WEST SUSSEX COUNTY COUNCIL CONSULTATION

TO:	Arun District Council FAO: Hebe Smith
FROM:	Highways, WSCC
DATE:	17/08/2026
LOCATION:	9 Ferringham Lane, Ferring, BN12 5QG
SUBJECT:	FG/65/26/S73 Application under Section 73 of the Town and Country Planning Act 1990 for the Variation of Condition 2 - Plans Condition following grant of FG/105/23/PL.
DATE OF SITE VISIT:	N/A
RECOMMENDATION:	Advice

THE LITTLE TIPPLE, 9 OCEAN PARADE, FERRING
Proposals 01 A
June 2023

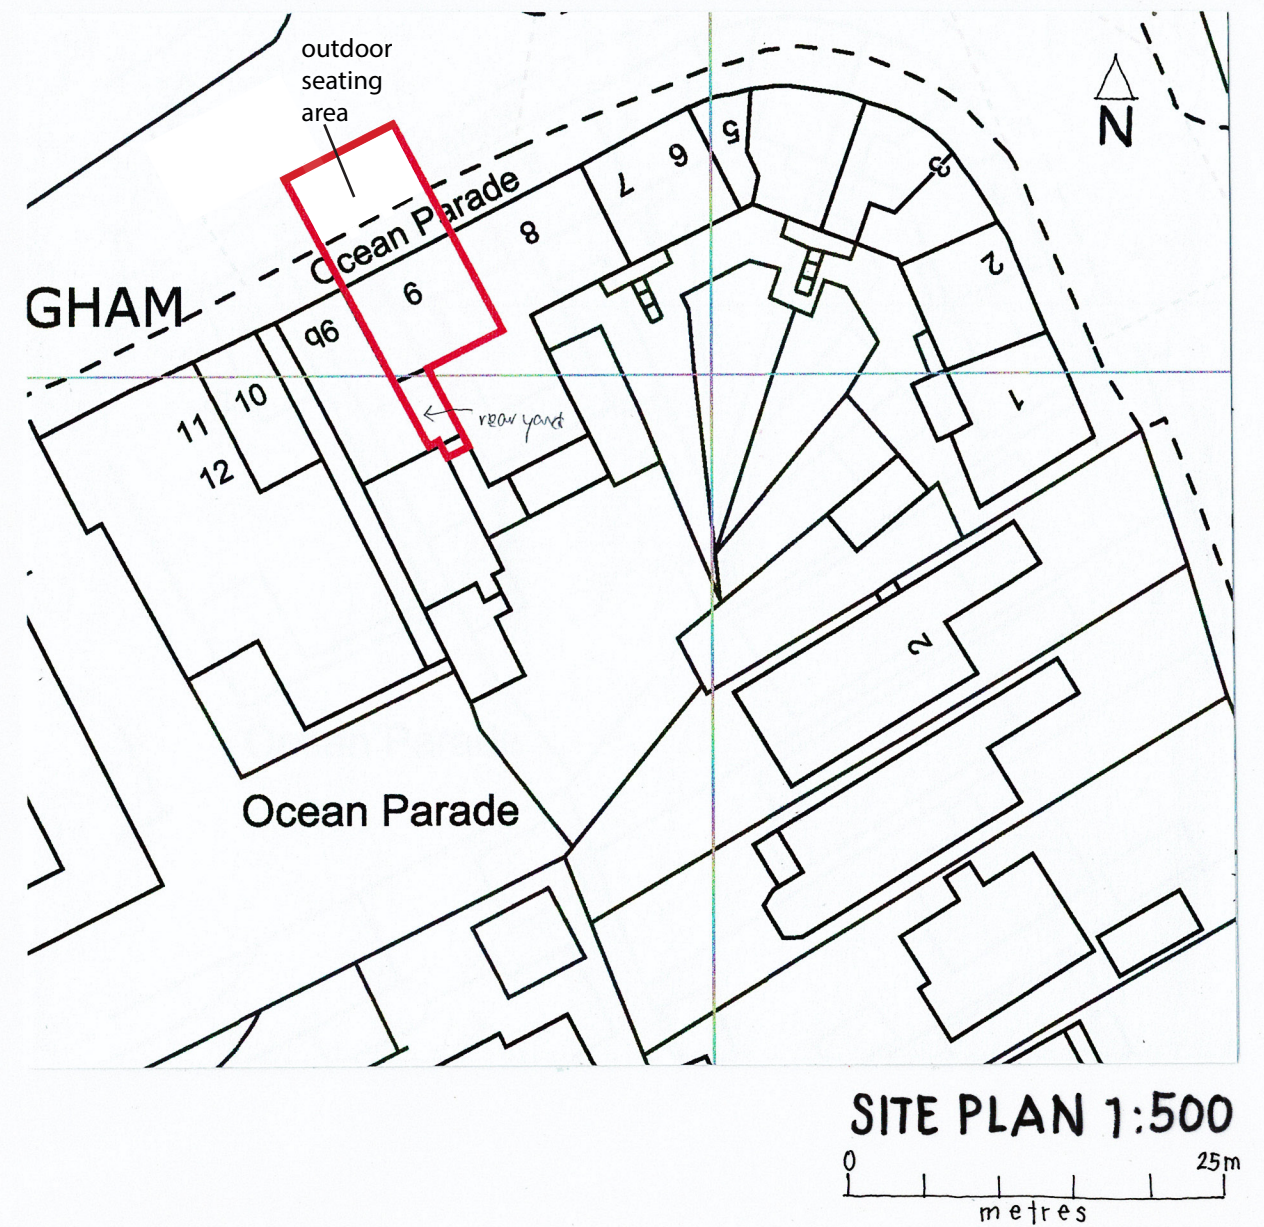
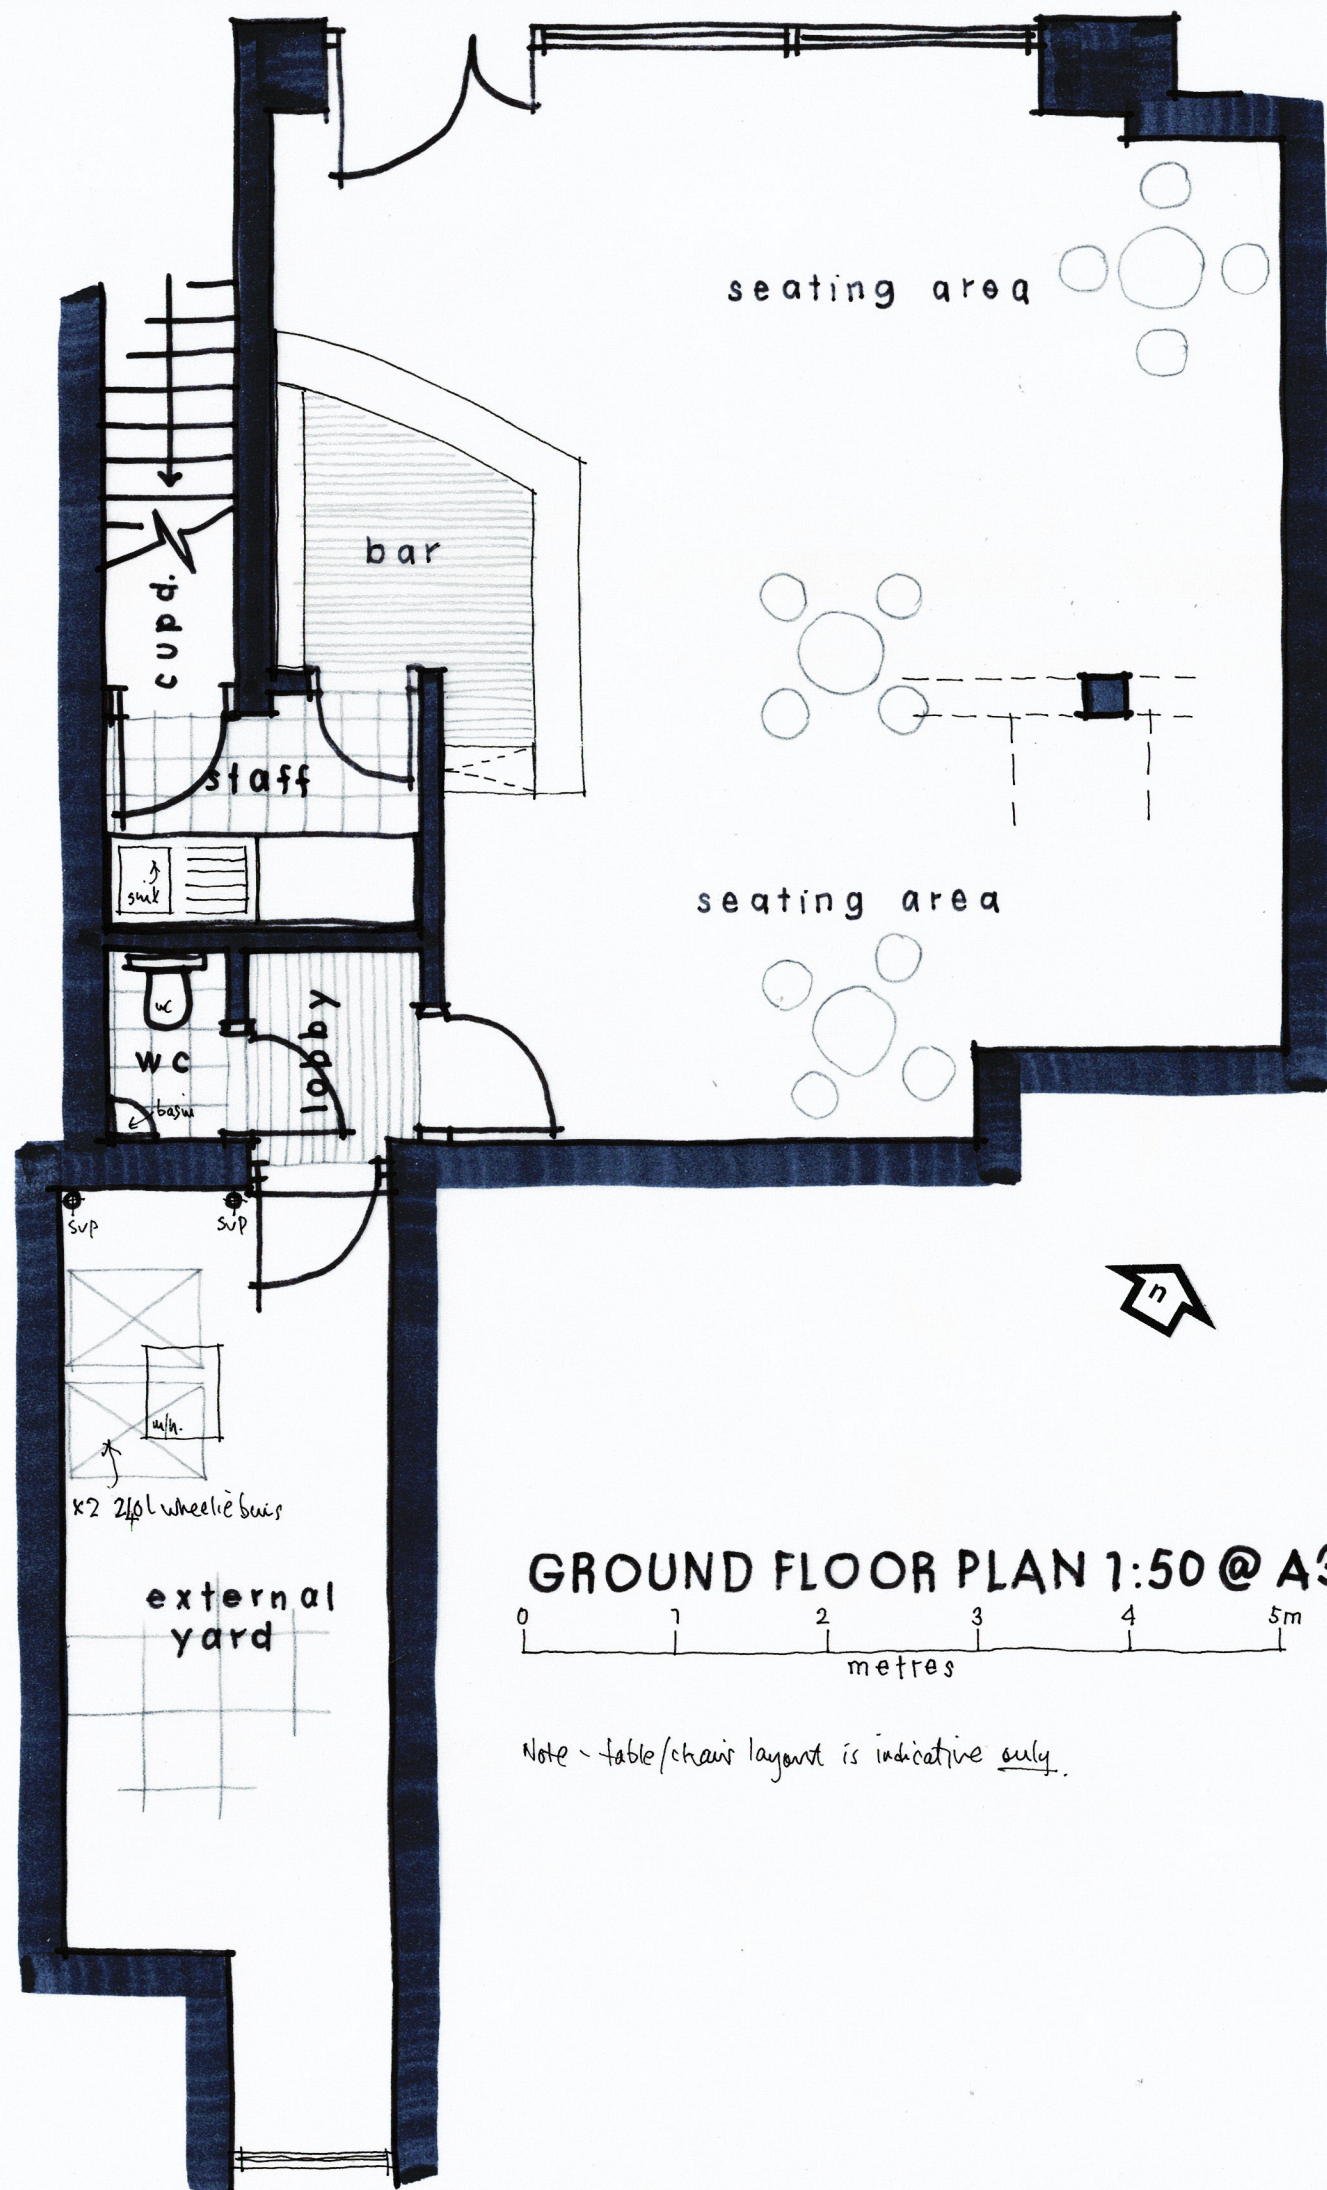
The proposals seek the formalisation of an outdoor seating area located on-street fronting the site on Ferringham Lane. I note that the approved plans for application FG/105/23/PL demonstrated three on-street car parking spaces in this location, so these would be lost as part of the proposals. Whilst no highway safety or capacity concerns would be raised in regards to this, the LPA are advised to consider the potential impacts on on-street parking that the proposals may have from an amenity point of view along this privately maintained road.
